One Earth Solar Farm

**Draft Statement of Common Ground with the Environment
Agency**

EN010159/APP/8.11.32

November 2025

Location Plan

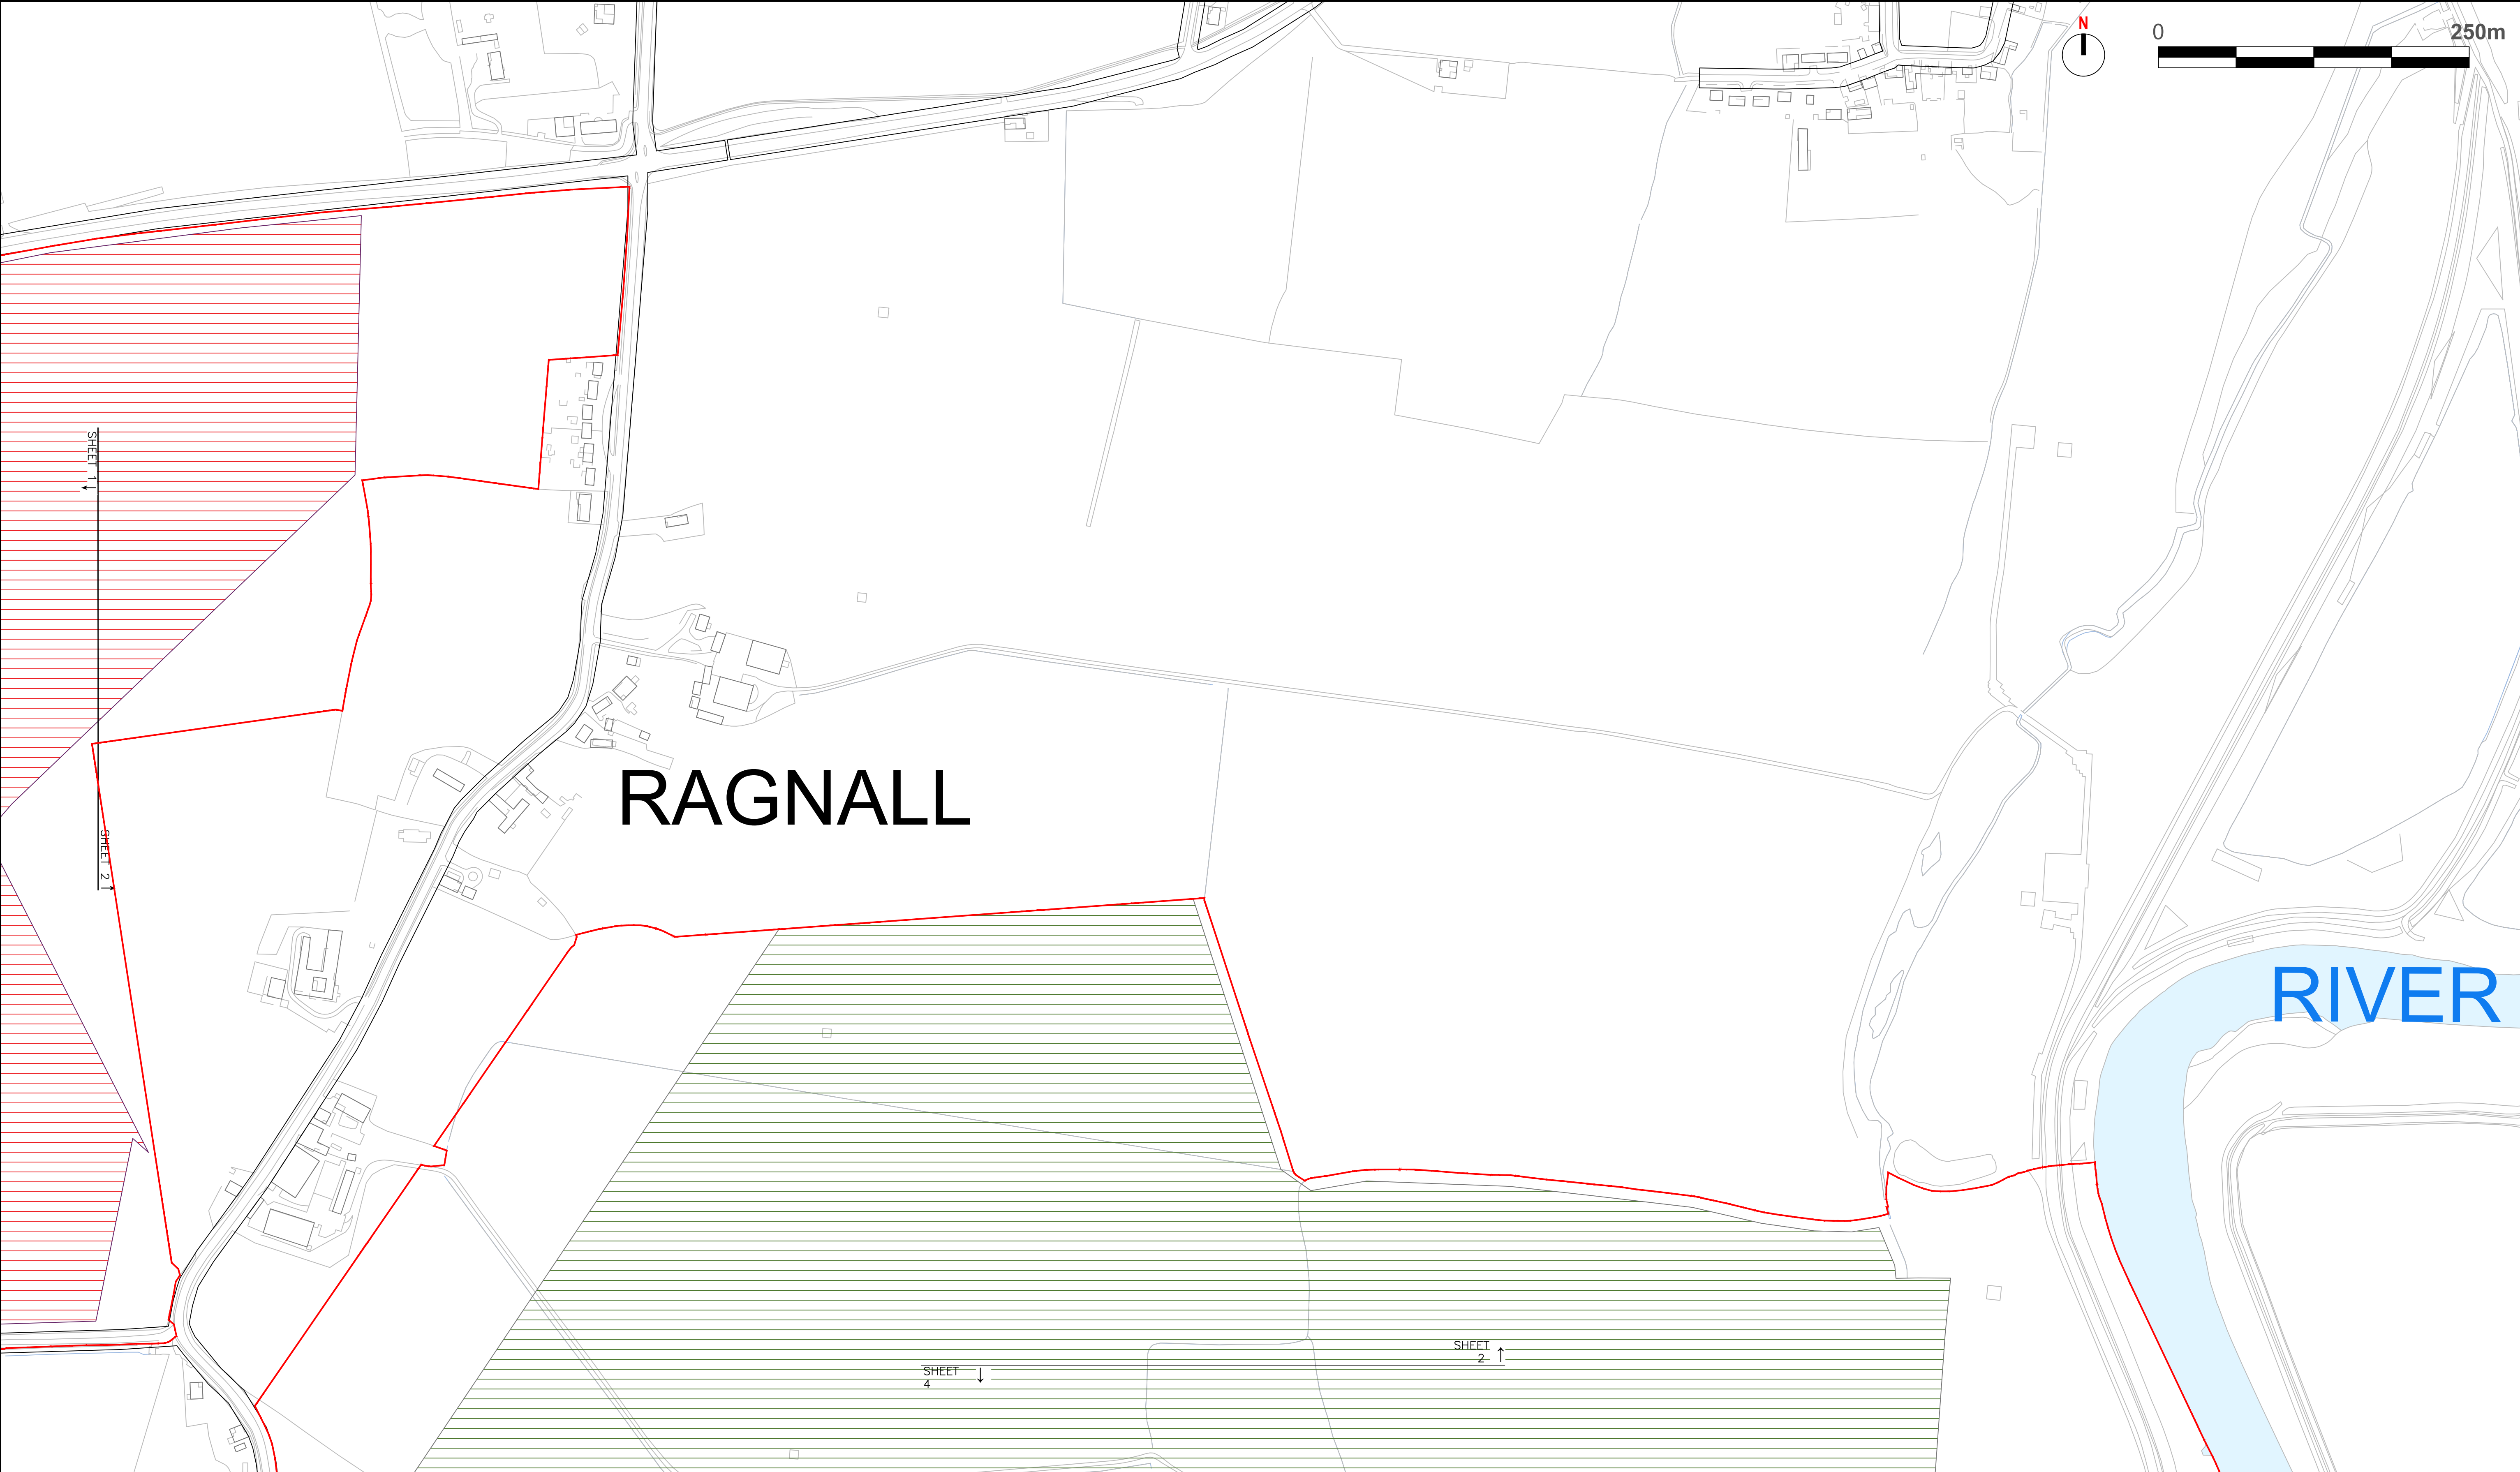
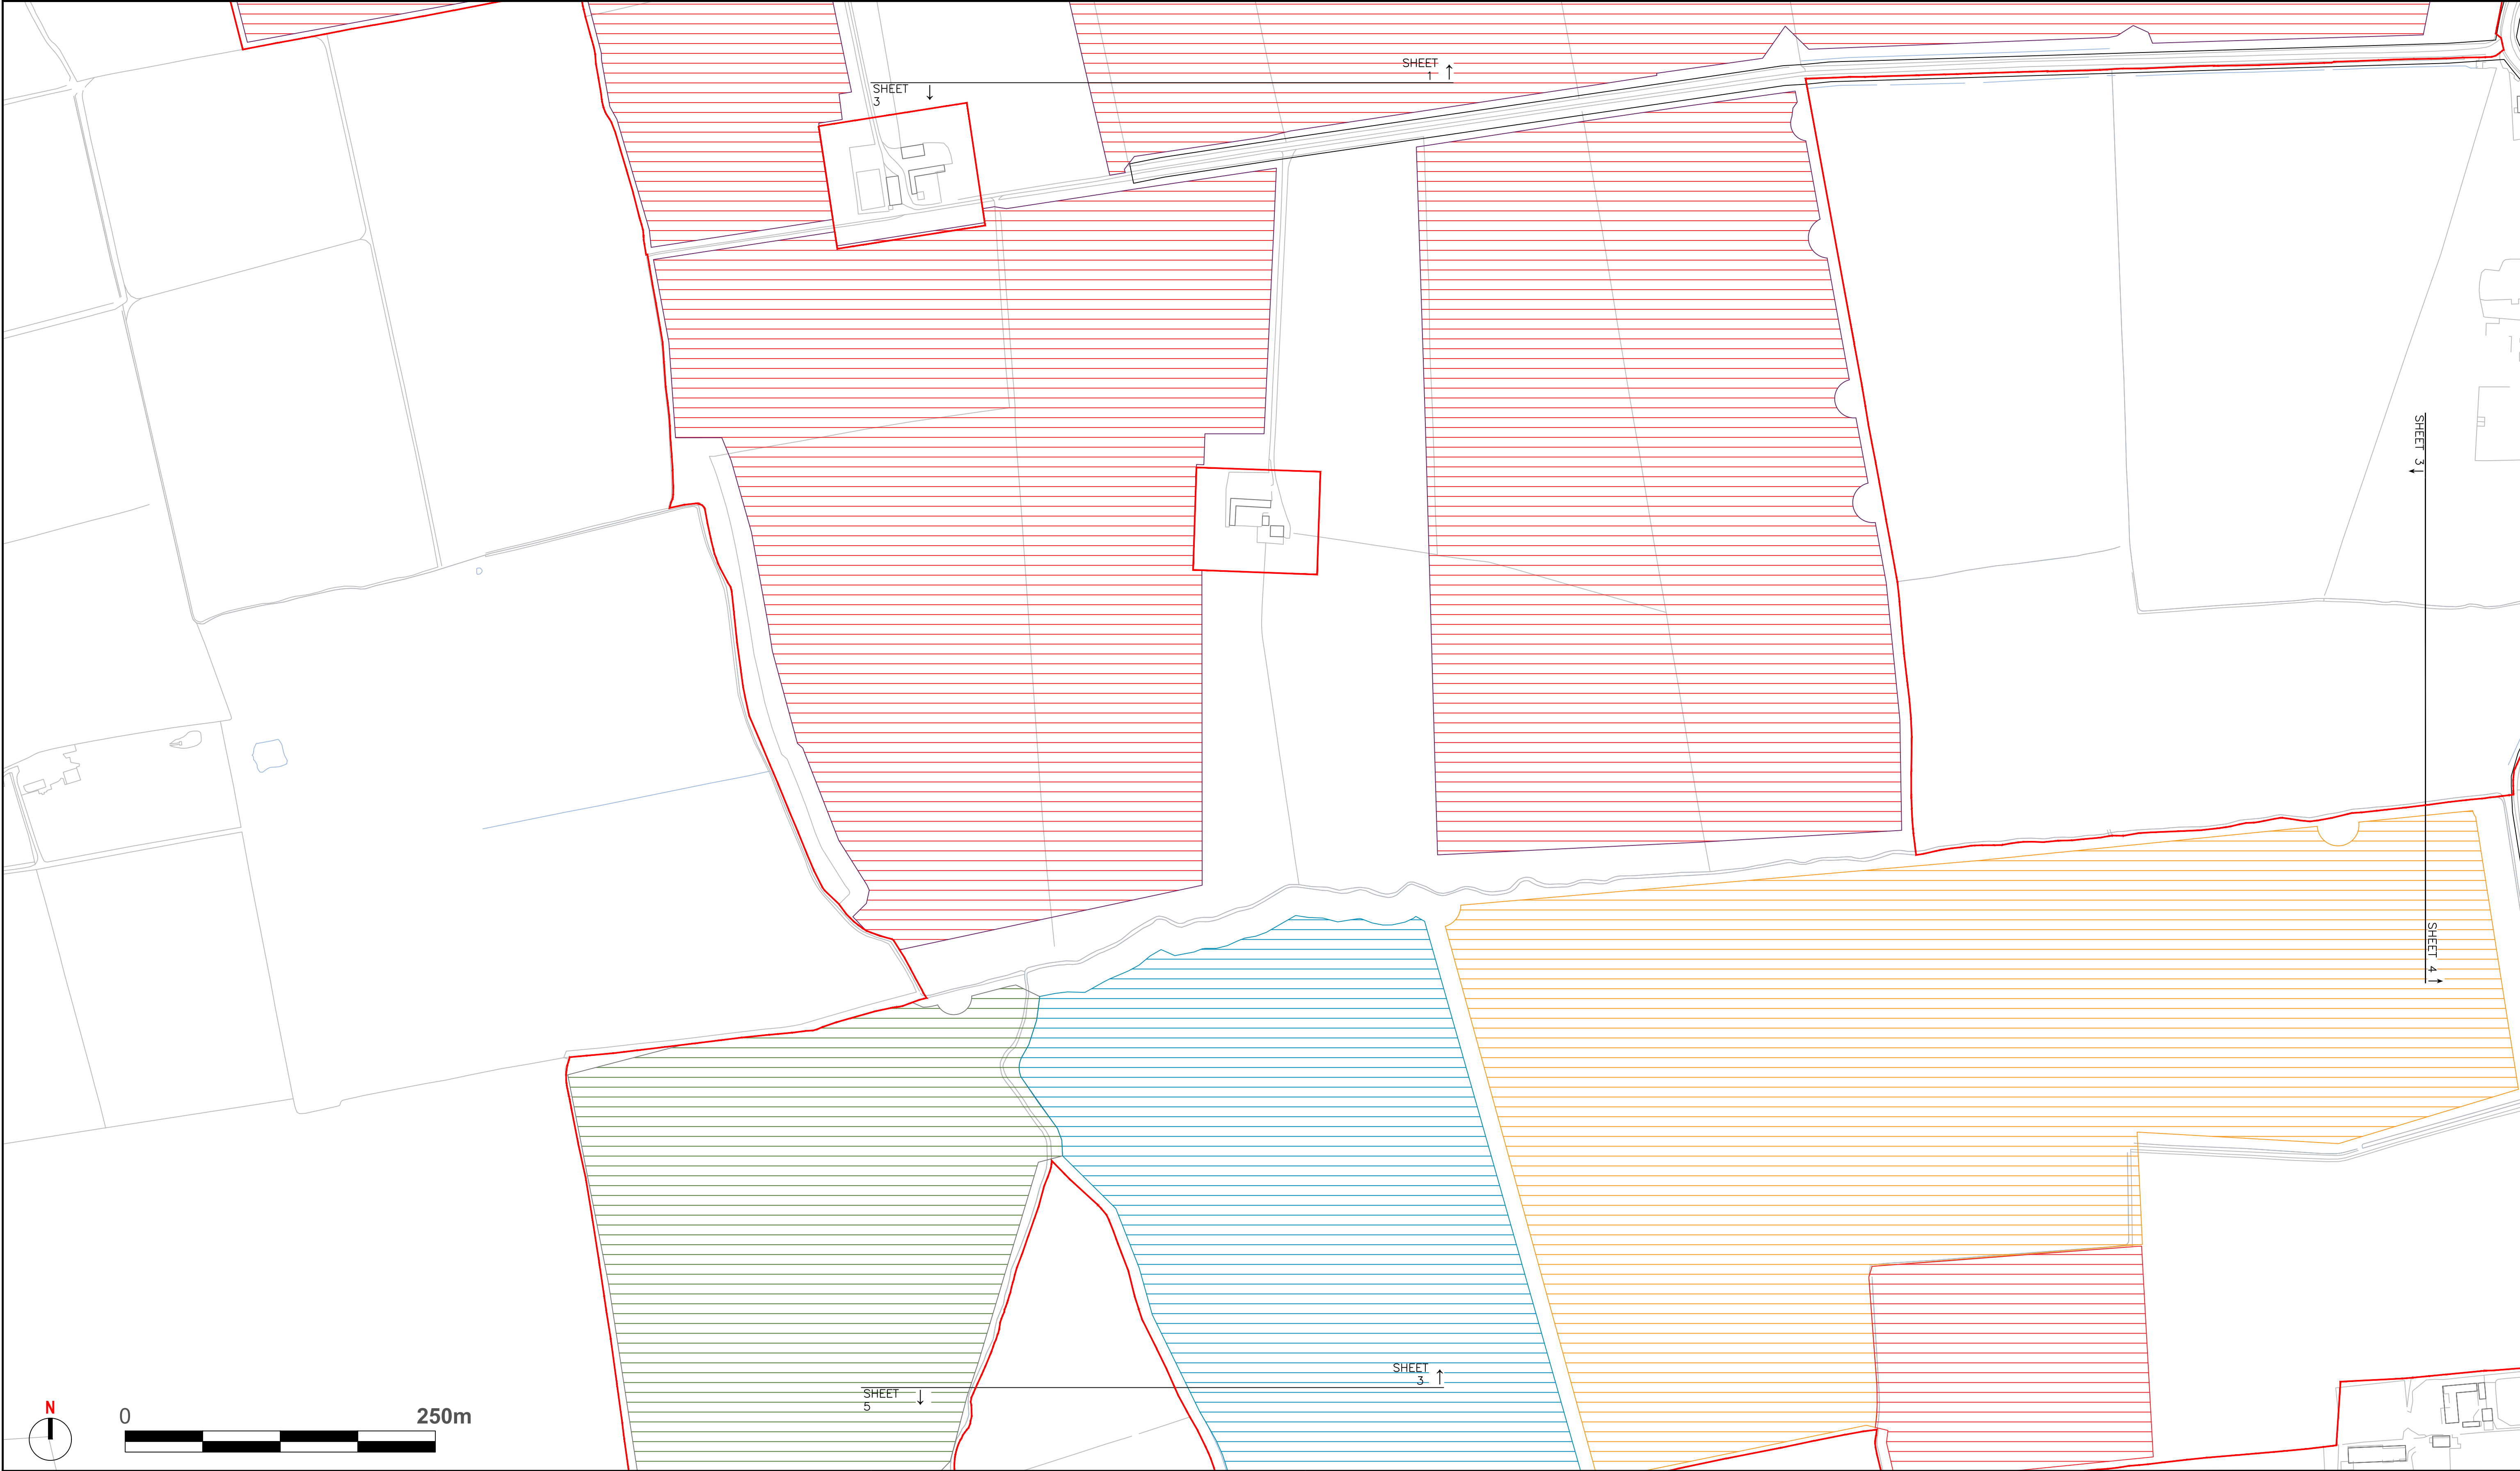
outside the design flood extent.		
02-03	Panel Raising	Applicant to provide a 300mm freeboard between the design flood level and base of panels wherever possible.	<p>It is proposed that a minimum of 300mm freeboard be provided across the majority of the Site by raising the bottom of panel heights. There are however, some localised positions where panels do experience a lesser freeboard.</p> <p>As a minimum, the base of the panels will be raised as required to ensure that the panels do not become submerged. This is achieved by adjusting the panel angle (within the 10 – 25 degree as set out within the outline design parameters) or by removing the bottom row of panels.</p> <p>By taking the above approach, it is confirmed that during the design flood event, the panels will not be submerged at any location within the Proposed Development, thereby ensuring the panels themselves will not impact flood flows or storage capacity.</p> <p>The EA have confirmed this matter is agreed following review of an updated draft of the FRA. The updated FRA will be submitted at Deadline 5.</p>	Agreed
